OXFORDSHIRE COUNTY COUNCIL'S RESPONSE TO CONSULTATION ON THE FOLLOWING DEVELOPMENT PROPOSAL

Application no: 14/02067/OUT

Proposal: New build Technology Park comprising 40,362 sq.m. of office, research and development, laboratory, storage and ancillary space

Location: Land East of Evenlode Crescent and South of Langford Lane, Kidlington

OXFORD TECHNOLOGY PARK PROPOSED SITE ACCESS

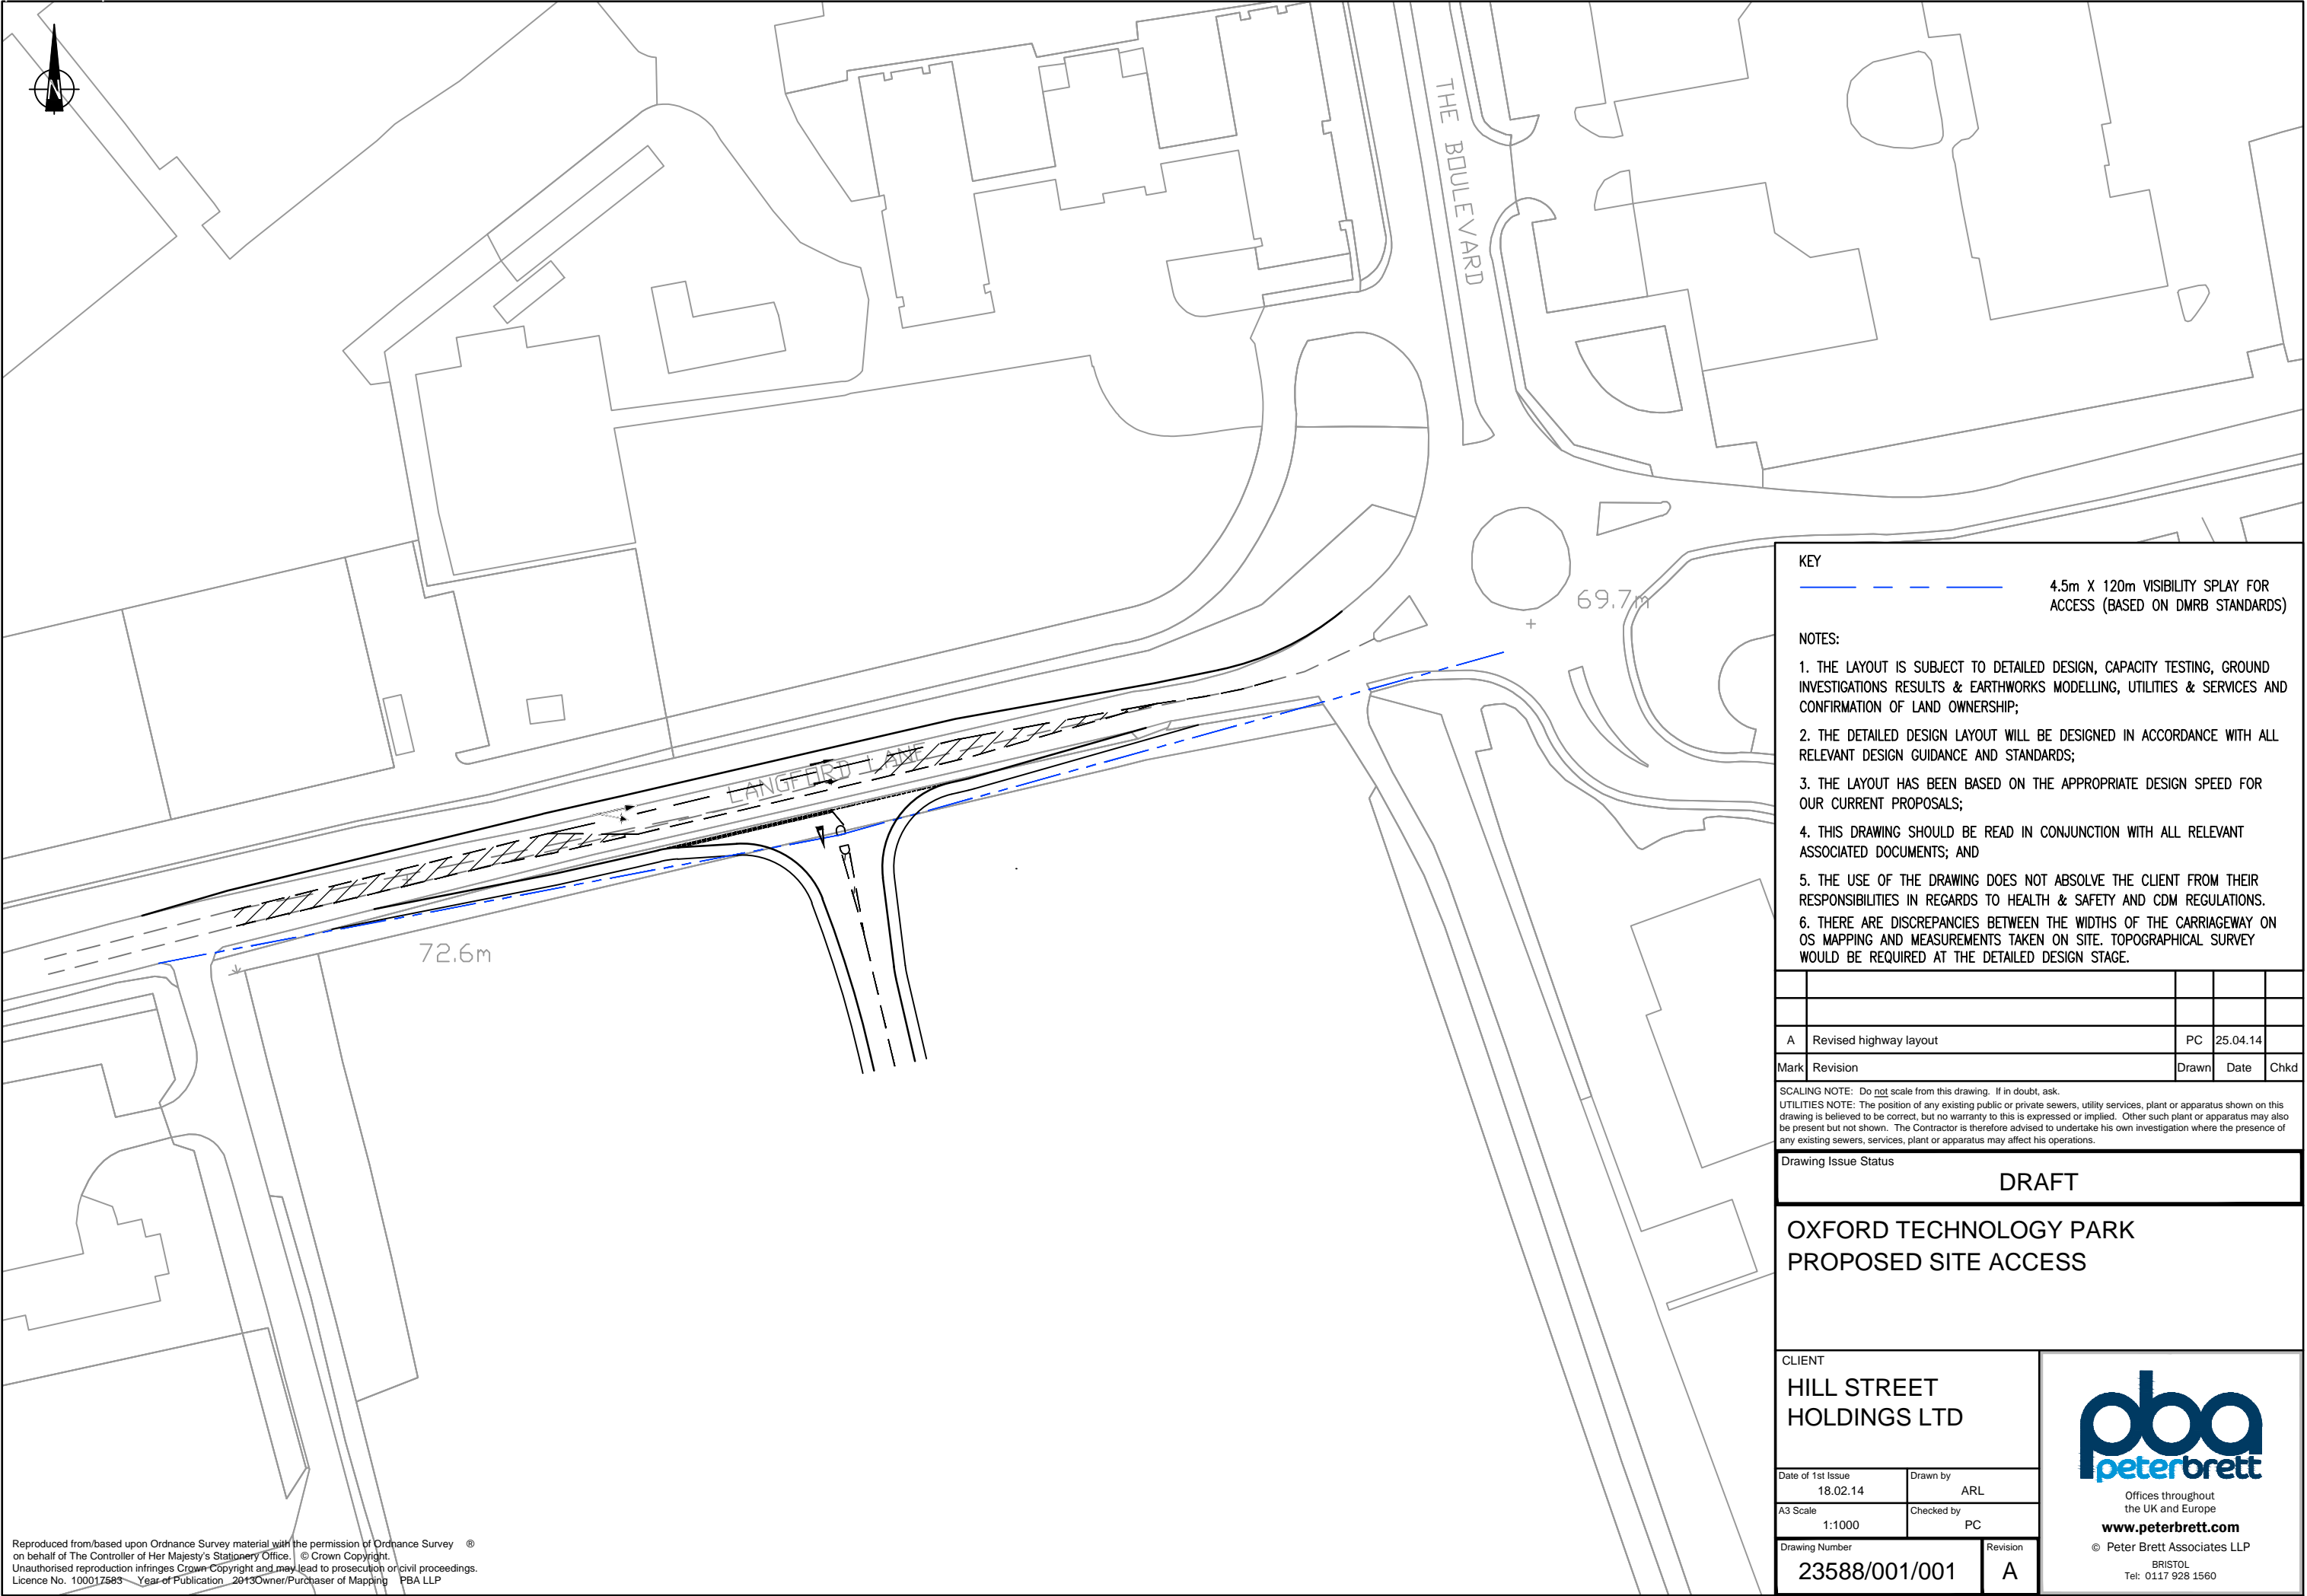
PBA Drawing 23588/001/001 shows the proposed junction layout. In addition to the capacity concern mentioned above, I have the following concerns with this drawing:

- The engineering report also contains a drawing of the access showing 70m vision splay. For the avoidance of doubt the vision splay should be as per Drawing 23588/001/001, i.e. 4.5 x 120m, due to the 85th percentile speeds. This will require some removal/cutting back of vegetation.
- The engineering report also shows no island to help pedestrians cross the junction whereas the drawing 23588/001/001 does. Neither drawing shows dropped kerbs. Both must be provided to sufficient dimensions to allow for a future shared ped/cycle route.

- The drawing shows widening (to accommodate the right turning lane) on the north side of Langford Lane. It is the applicant's responsibility to check for highway boundary and land ownership issues.
- Tie in with right turning arrangements for Evenlode Crescent should be shown.
- Lane widths and key dimensions should be shown on the drawing.
- The 1.8m footway along the front of the site should be widened to accommodate shared ped/cycle use.
- To improve access to the bus stops in The Boulevard, a crossing point should be provided closer to the site, with a pedestrian refuge in the hatched area and a new section of footway on the north side of Langford Lane. The current crossing point is uncomfortably close to the roundabout.
- HGV swept path drawing for the access should be provided.

Date of 1st Issue	25.04.2014	Drawn by	JHo
A3 Scale	1:500	Checked by	PC
Drawing Number	23588/001/SK004	Revision	-

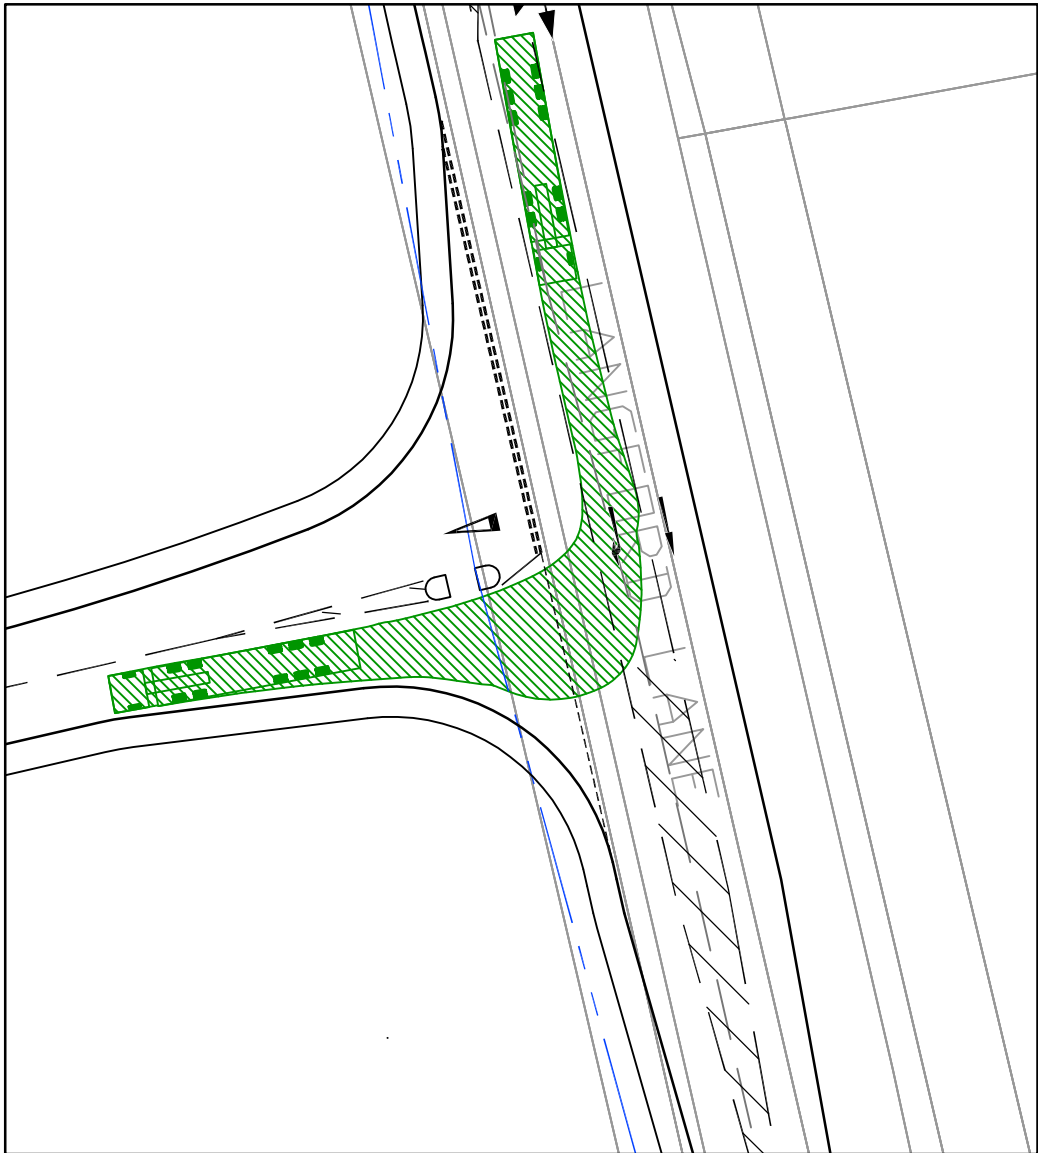
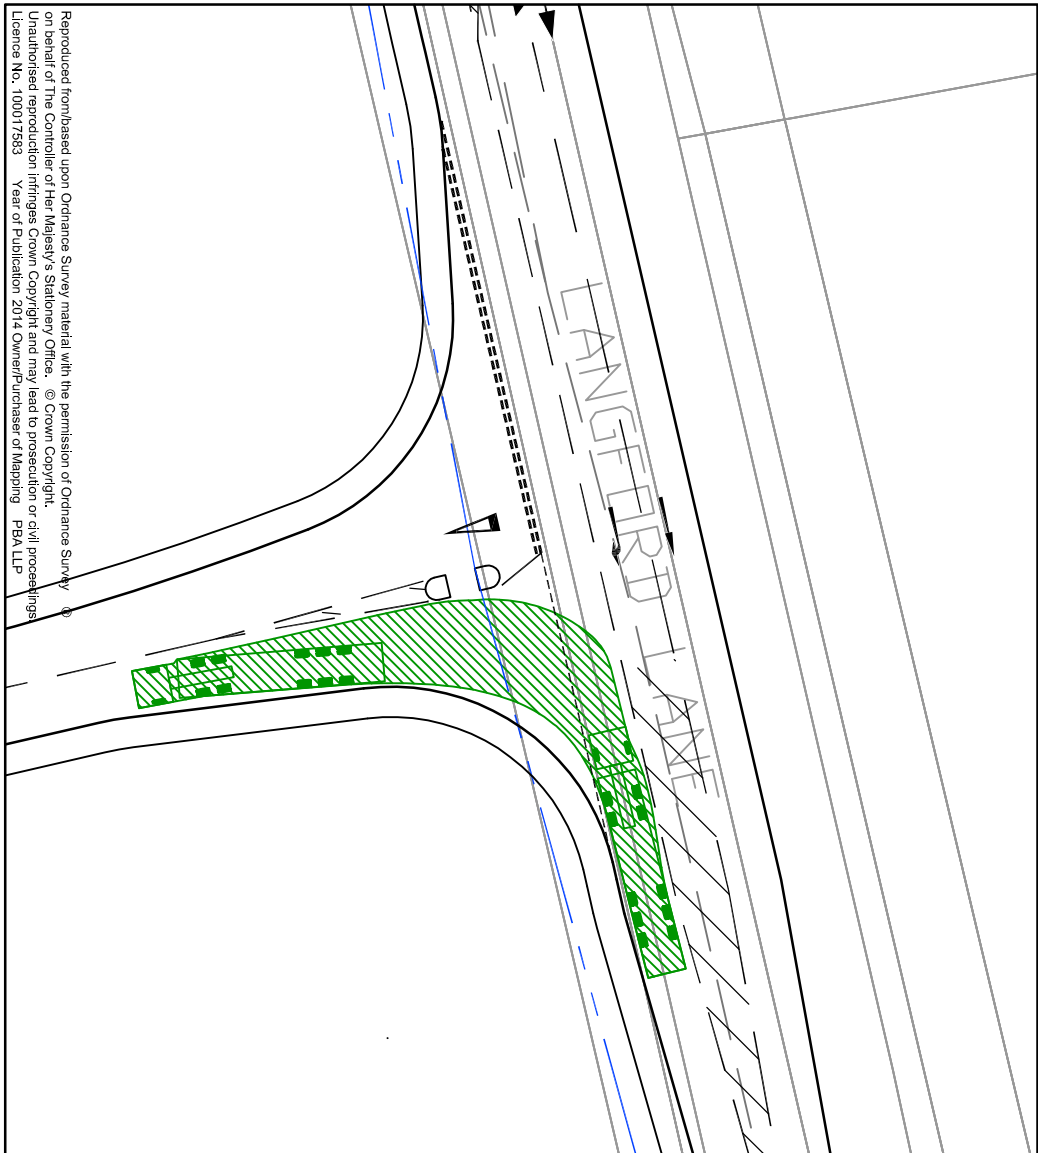
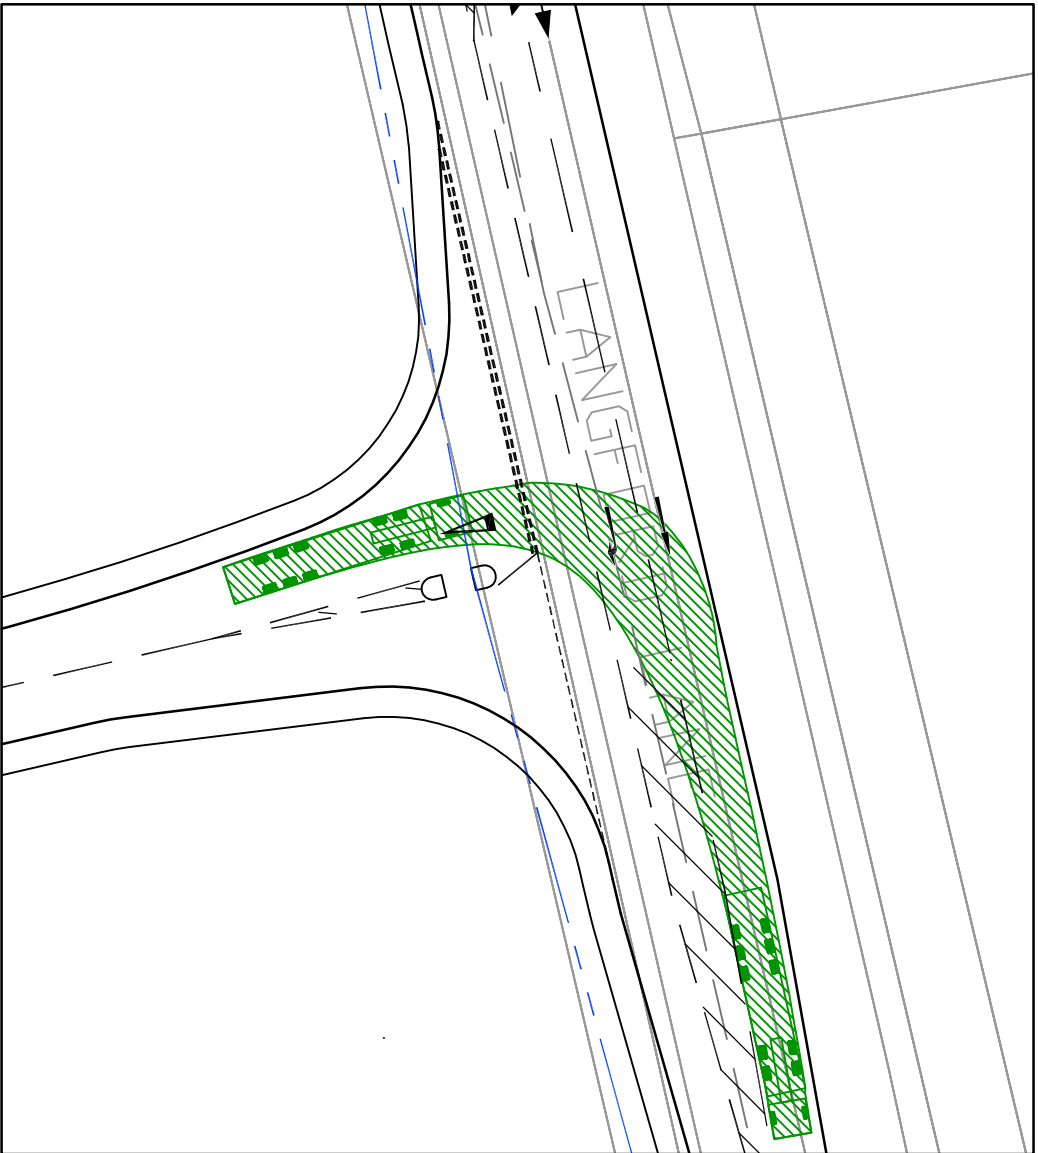
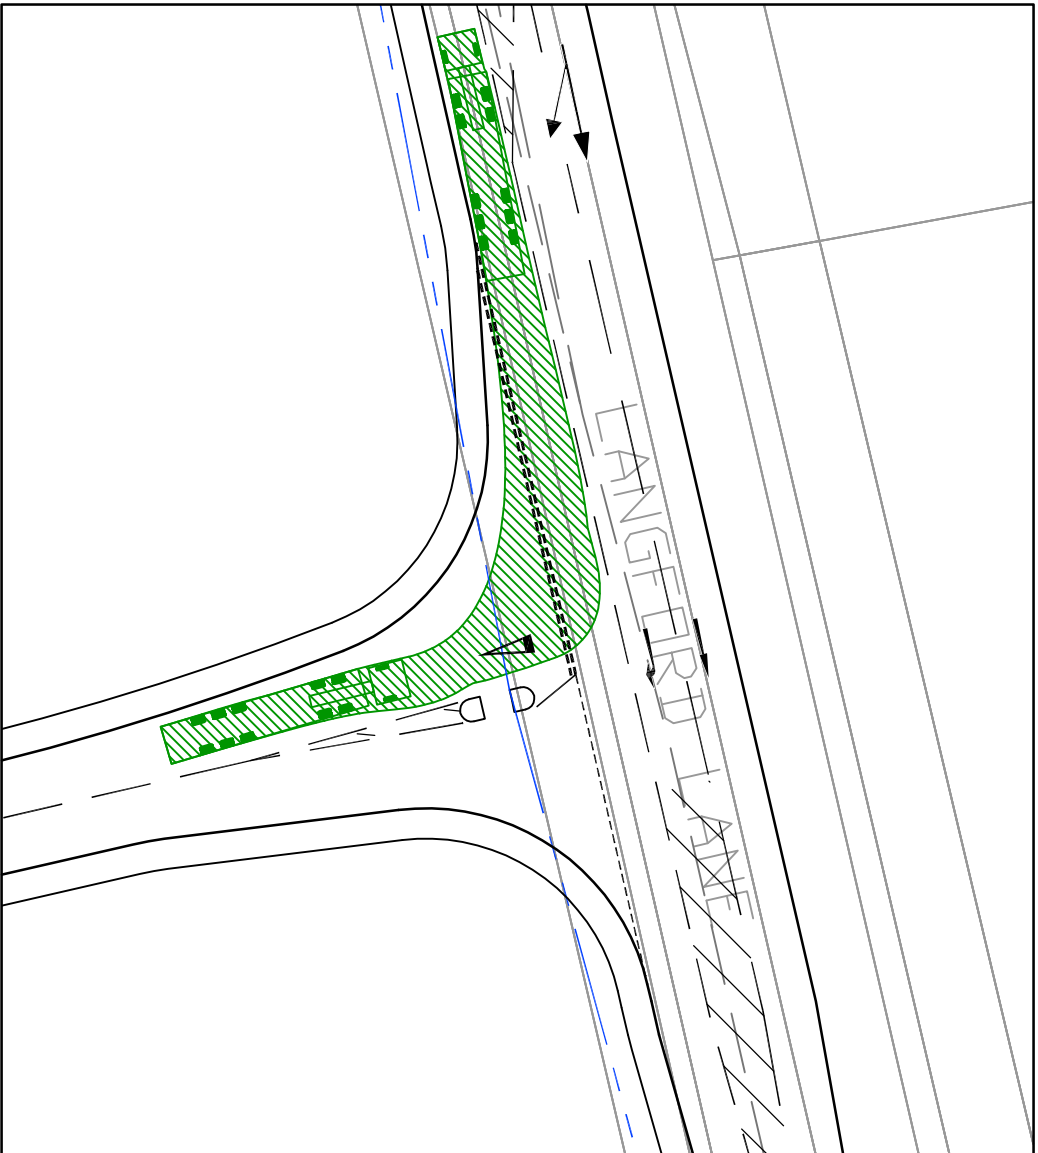
- Cycle parking not shown
- Tracking shown in the engineering report is for a different layout – full HGV tracking will be required, covering full route through the site.
- Close attention will need to be paid to the quality of the walking route through the site
